From: Jack, Isabella [redacted]
Sent: 04 February 2021 10:57
To: Planning <planning@oxford.gov.uk>
Subject: NE Response - 21/00100/FUL

Consultation: Demolition of existing front porch. Formation of front porch | 8 Benson Road Oxford
OX3 7EH

Ground Floor, First Floor
& Roof Plan
Proposed

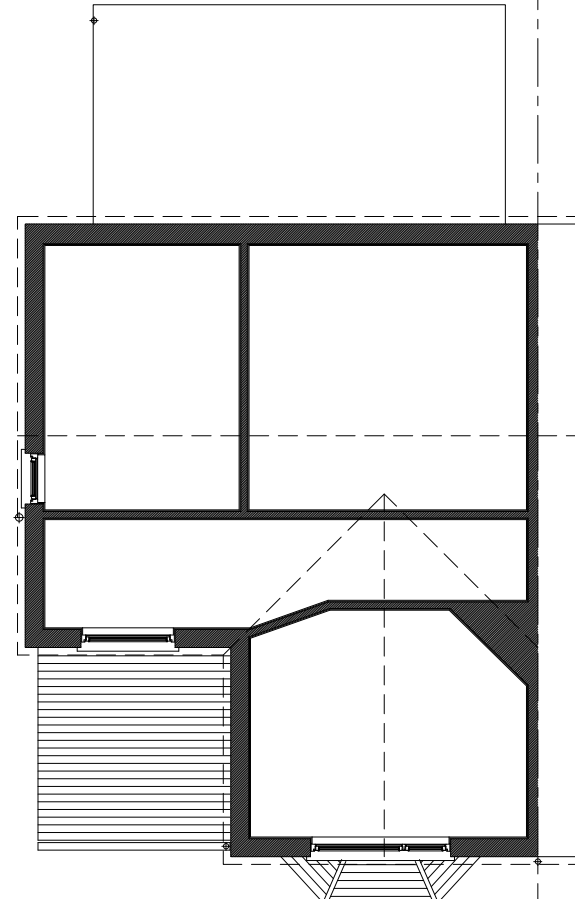
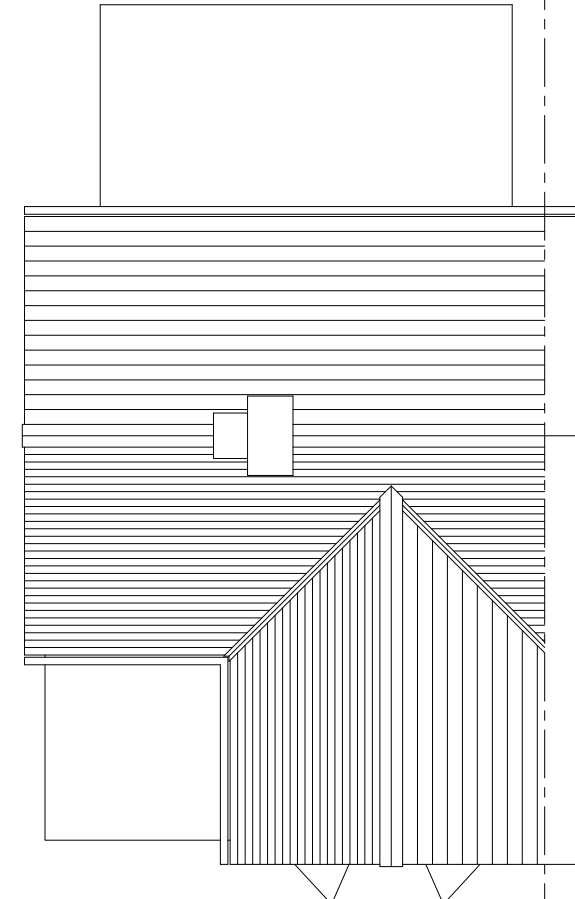
Thank you for consulting Natural England on the above application. The site falls within an area that is likely to be within the hydrological catchment of the Lye Valley SSSI, for this reason it would be helpful if you could clarify please the means by which surface water will be disposed of e.g. will run-off from the extended porch go to soakaway? It is also unclear from the application whether the additional roof space of the porch is replacing existing hard standing, or if it is an area that is currently not built on.
